**CITY OF PORTLAND, MAINE
HISTORIC PRESERVATION BOARD**

January 8, 2018

Re: 40 Bowdoin Street – replace one kitchen window
CBL: 070 D007

Drawing file: Plans / Window Detail.pdf

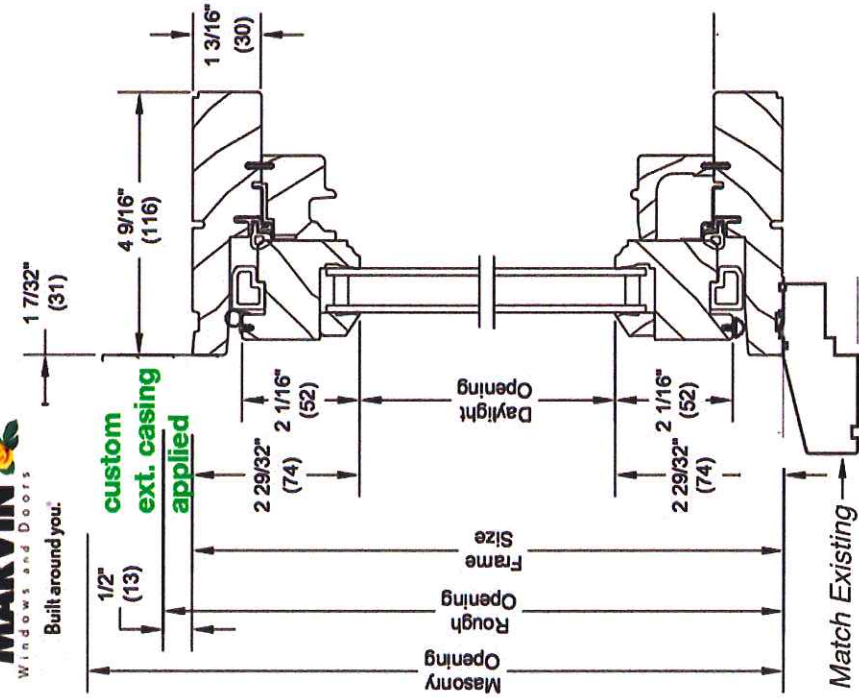
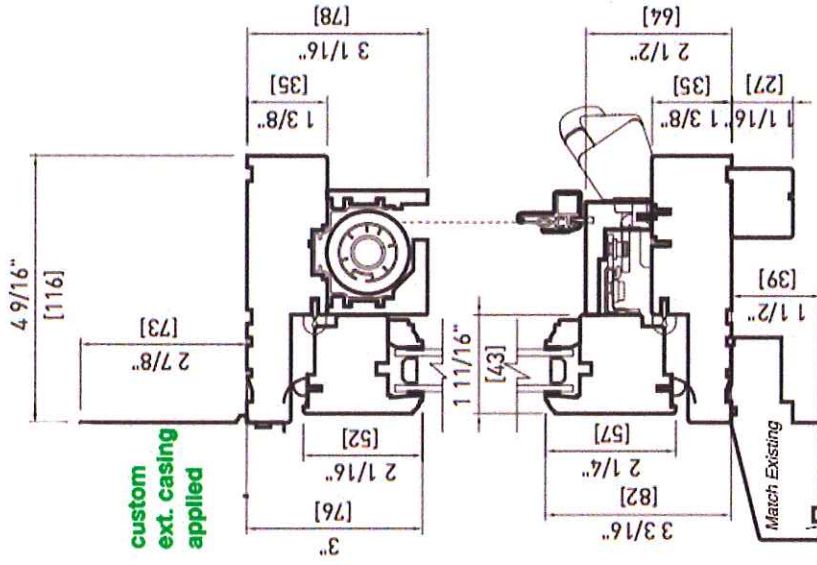
- HP staff understands the exterior appearance of the proposed new window is to match as closely as possible the appearance of the existing window. Head height is to be as close as possible to the head height of the existing, nearby, small lavatory window, while maintaining the existing sill height.
